10 July 2015

**NOTIFICATION OF MODIFICATION APPLICATION FOR NEW SPACE PROJECT -
UNIVERSITY OF NEWCASTLE (SSD 6457 MOD 1)**

DRAWING No. DA-200

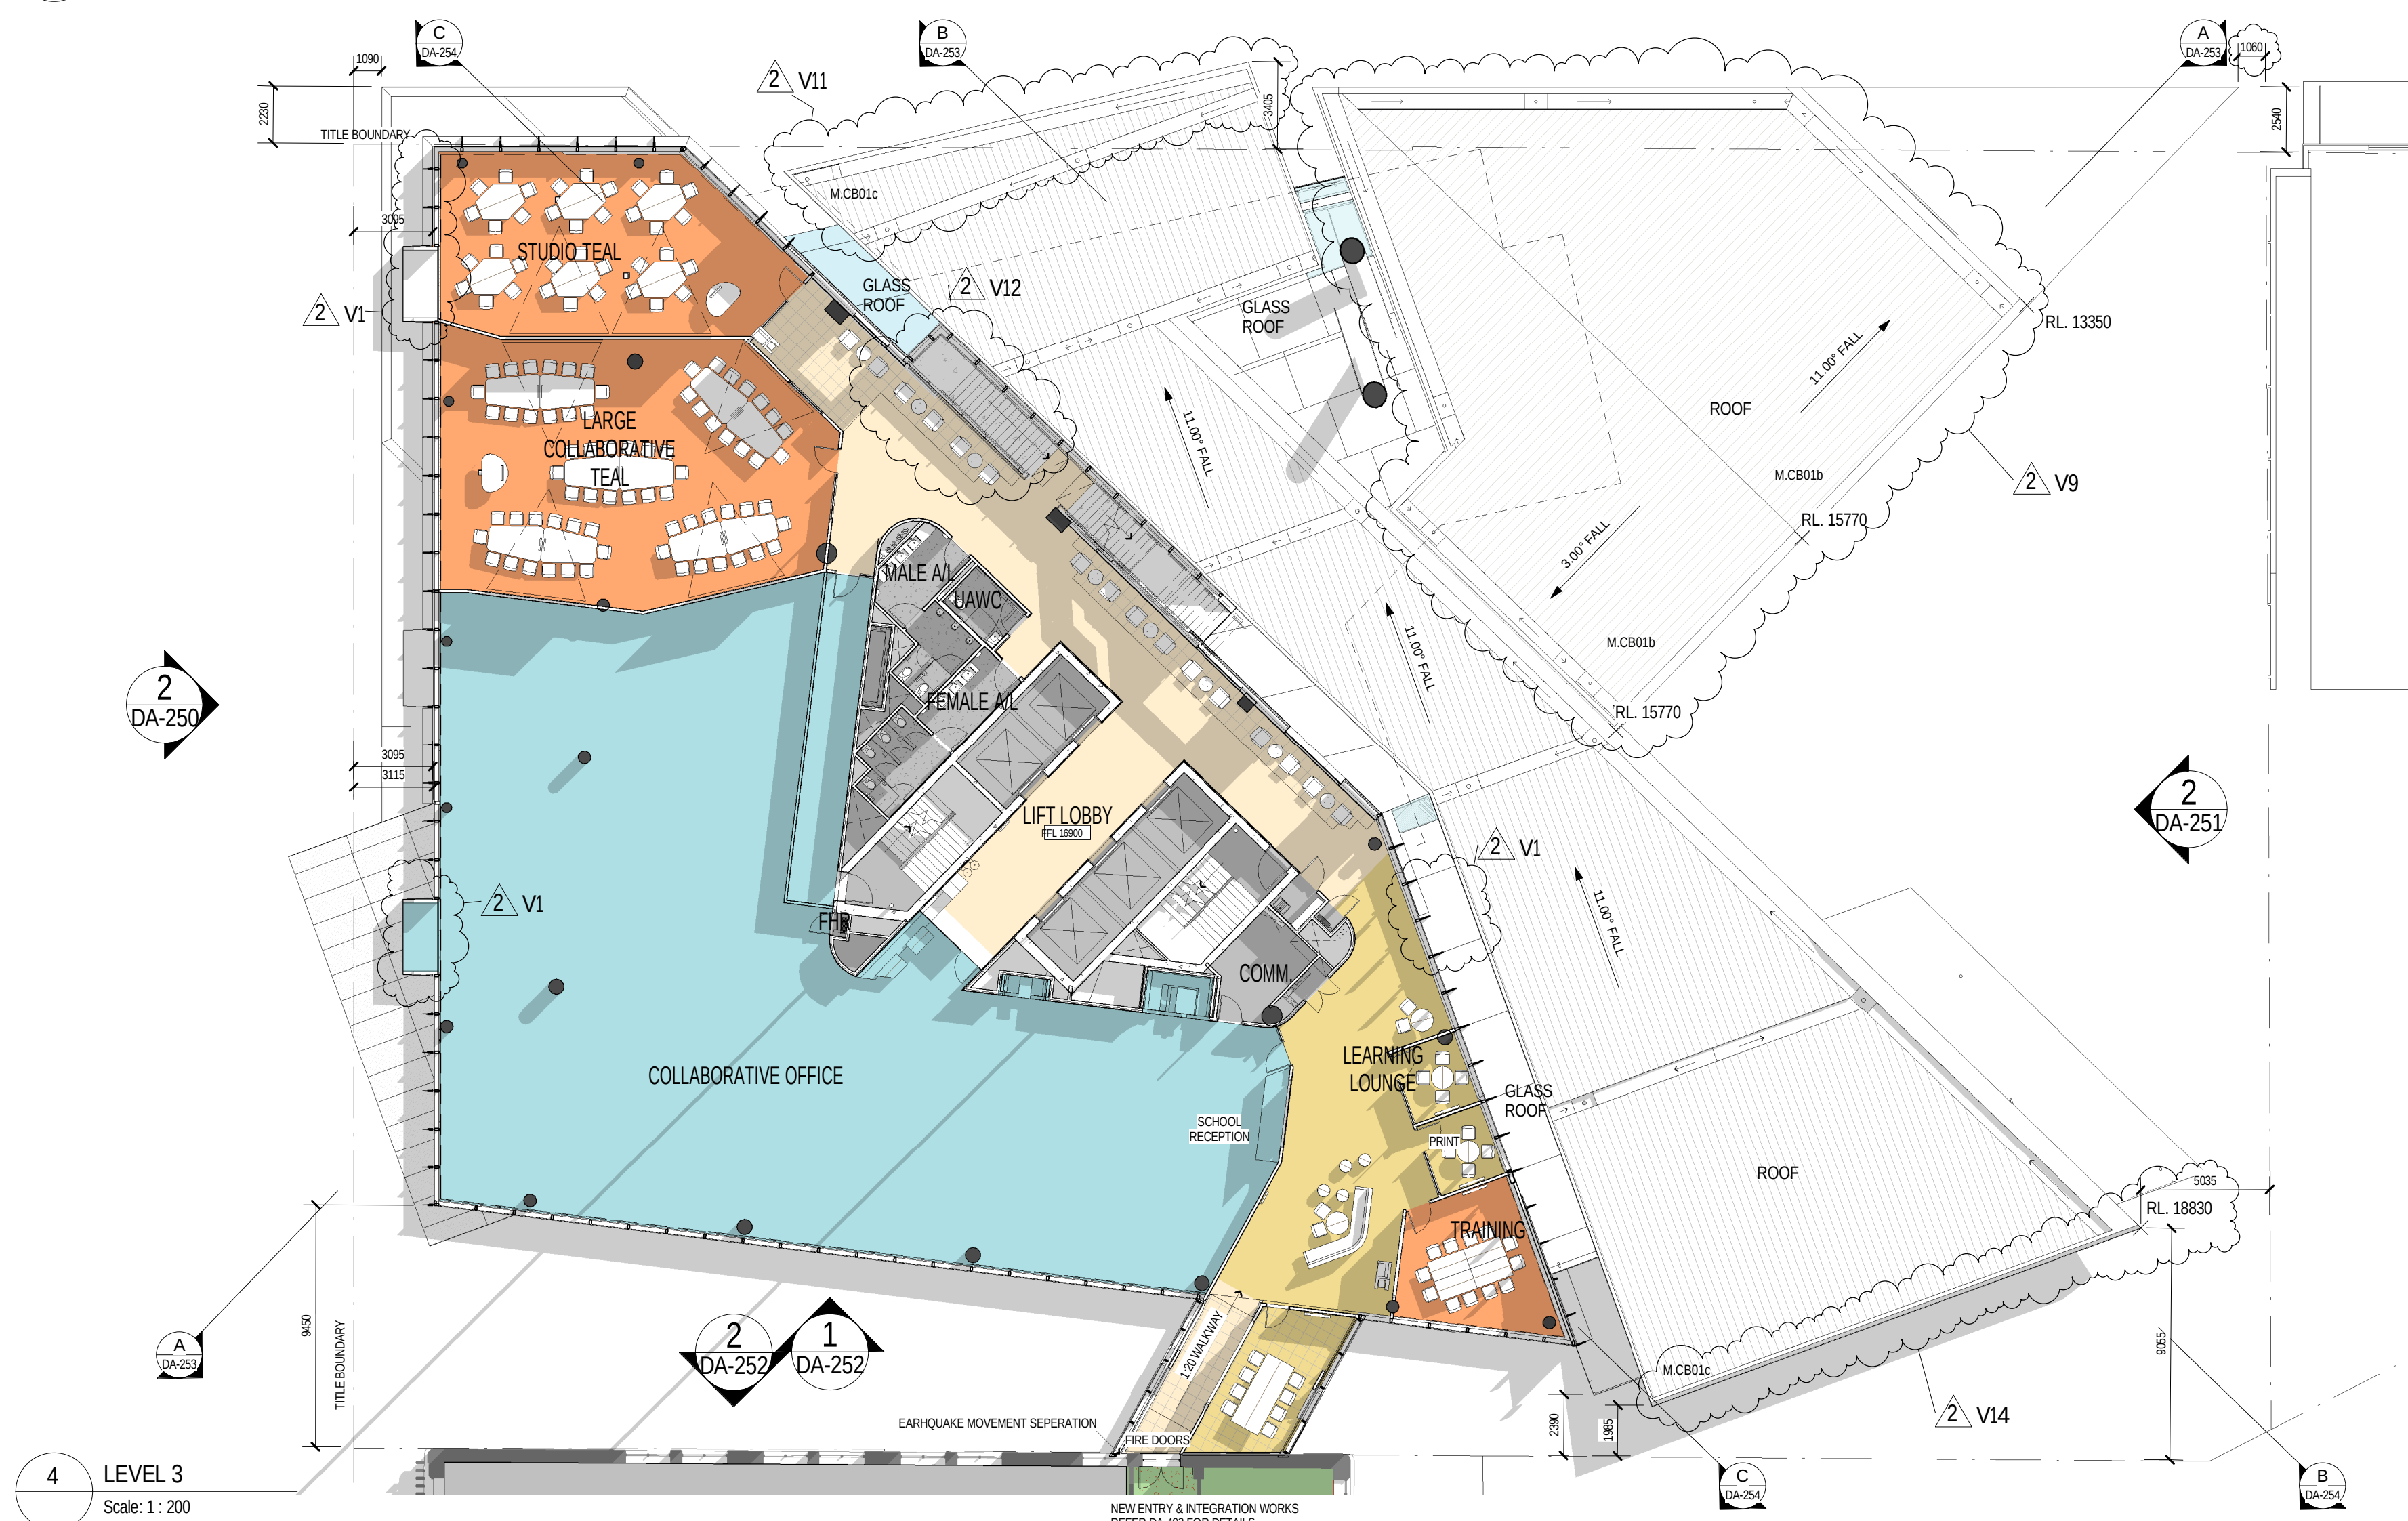
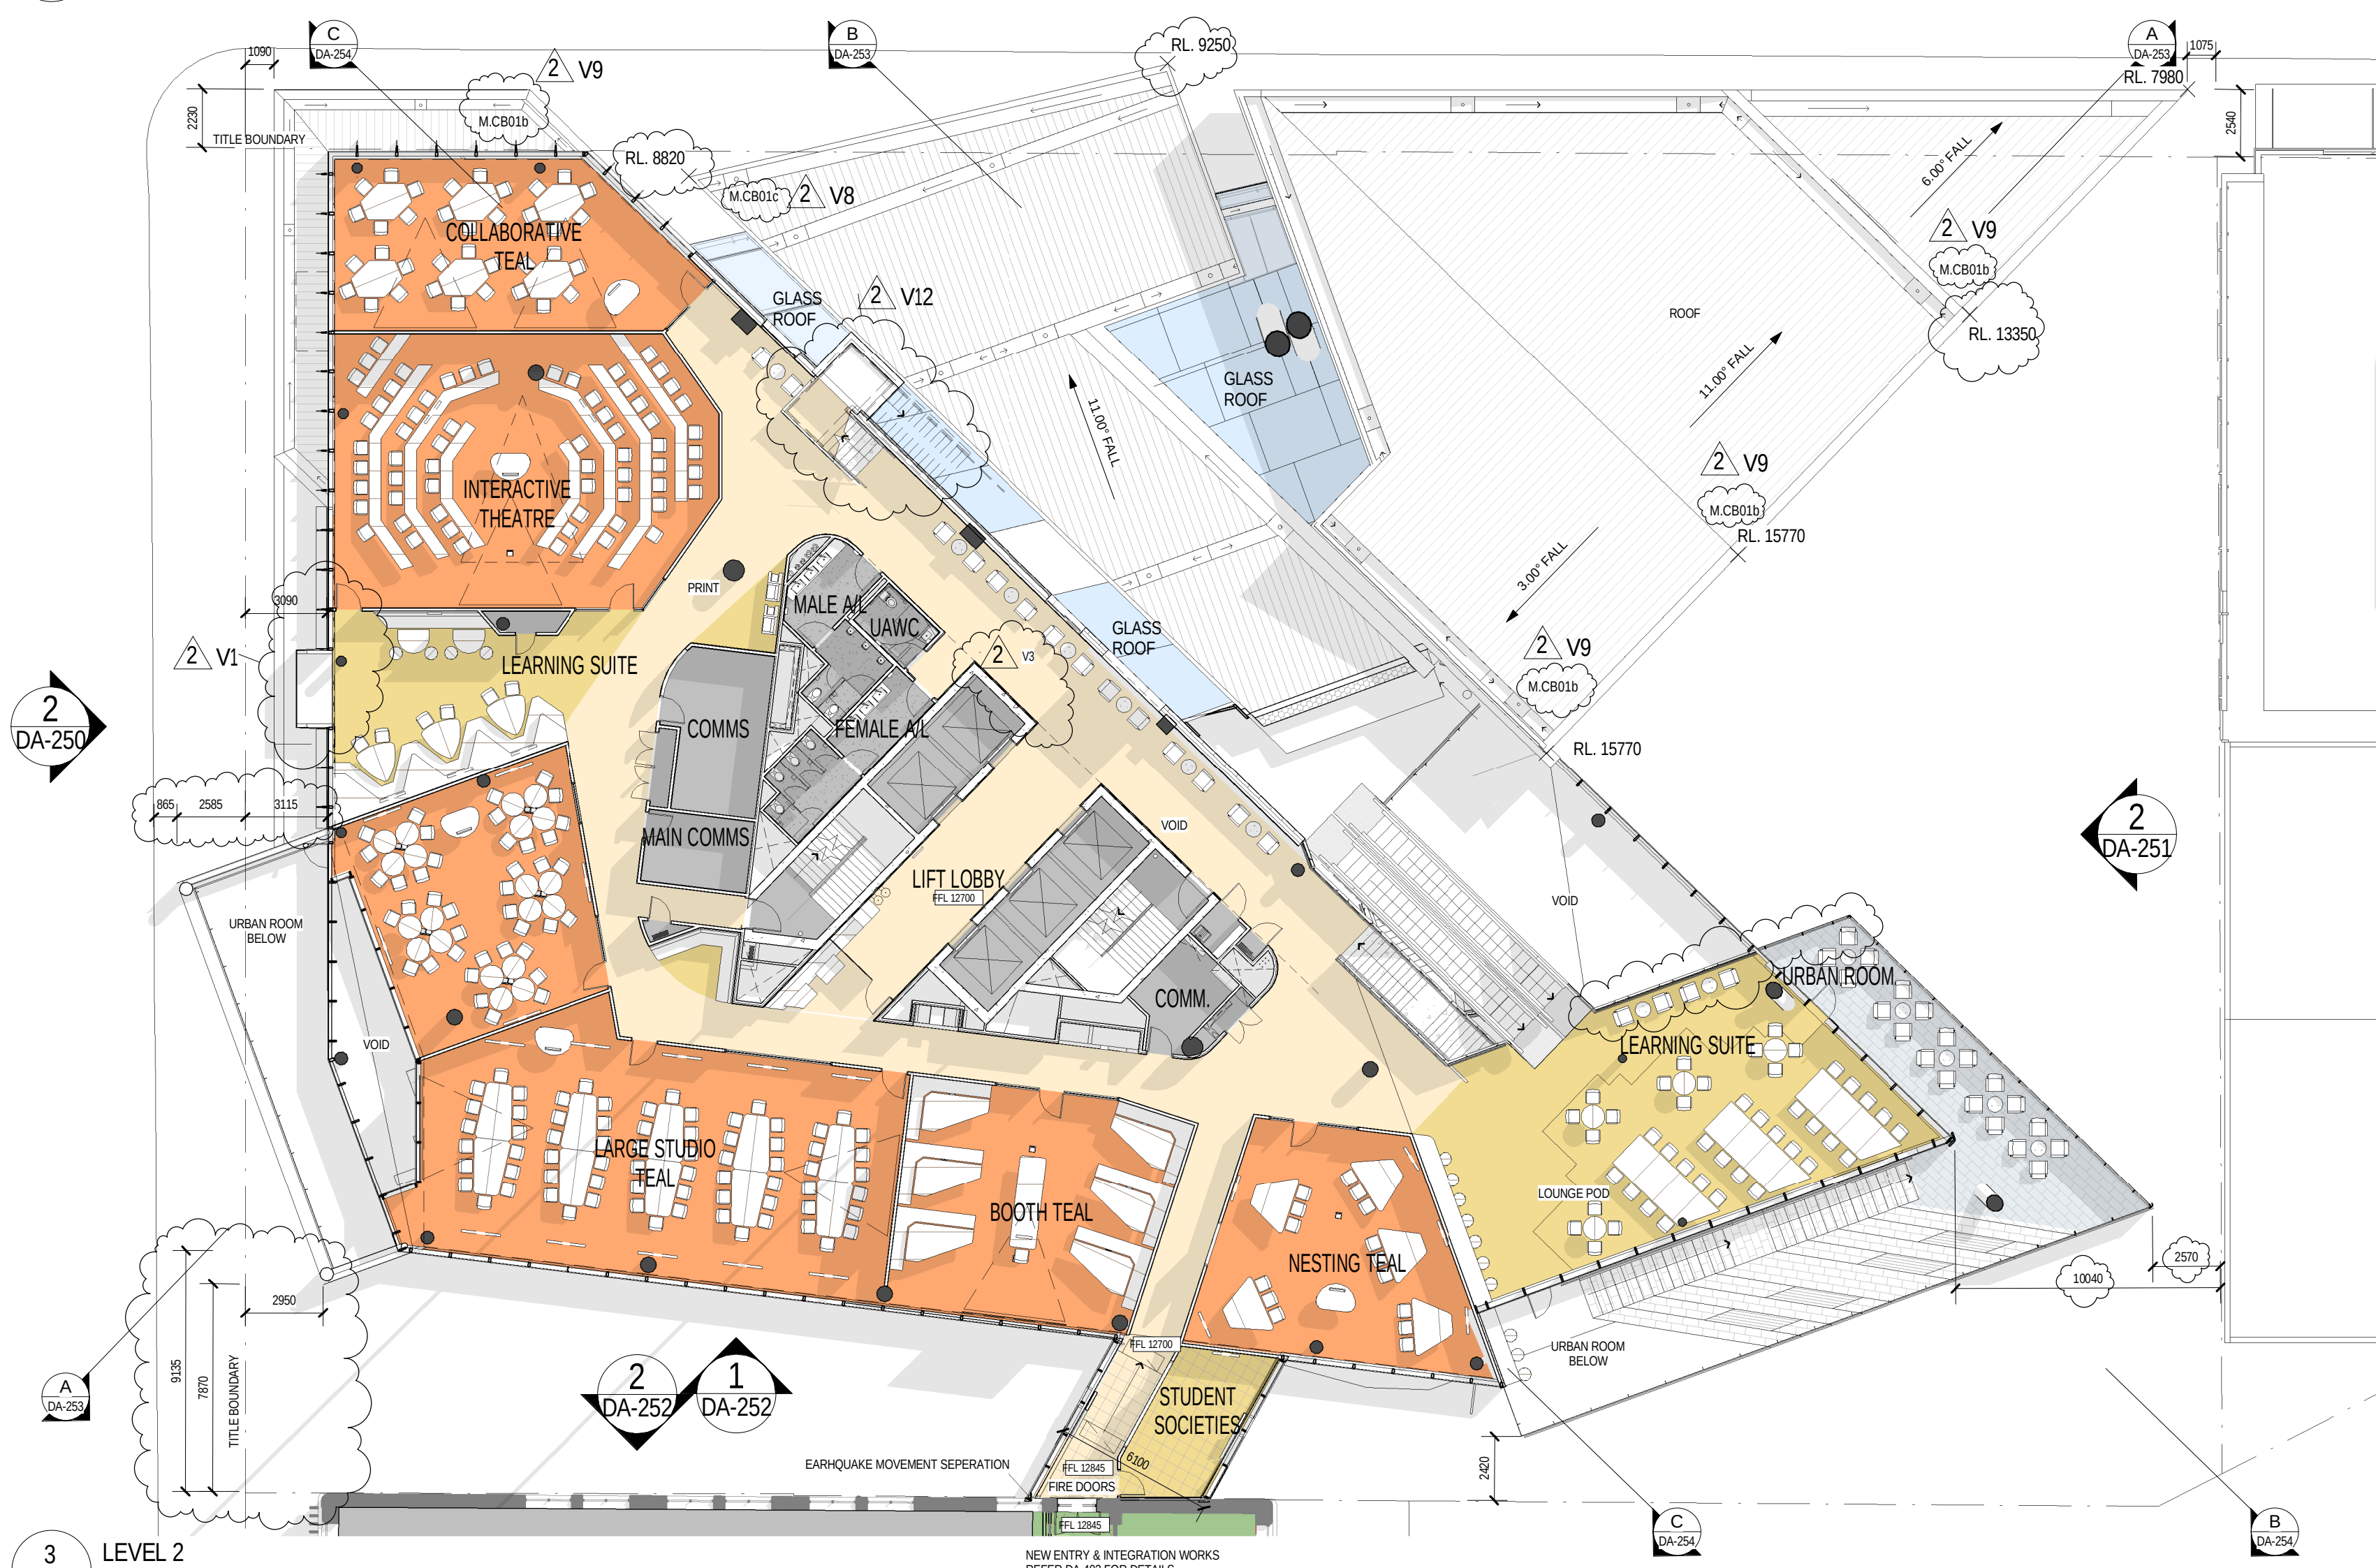
- There is no description in the JBA letter dated 11 June, 2015 to the modifications V9, V14, V20 and V32 indicated on the amended plans. Similarly, there is no explanation for the inclusion of modification 'clouds' around the building setbacks distances indicated on drawing DA-200.

- The notation '*Urban Room Balcony Over*' on the ground floor drawing is misleading and should be removed. The Urban Room on level 1 is an enclosed space which forms part of the gross floor space of the building.

It is recommended the applicant be required to highlight the proposed modifications onto the relevant approved design plans or alternatively submit amended design plans so that the proposed changes to the design of the building are clearly distinguishable.
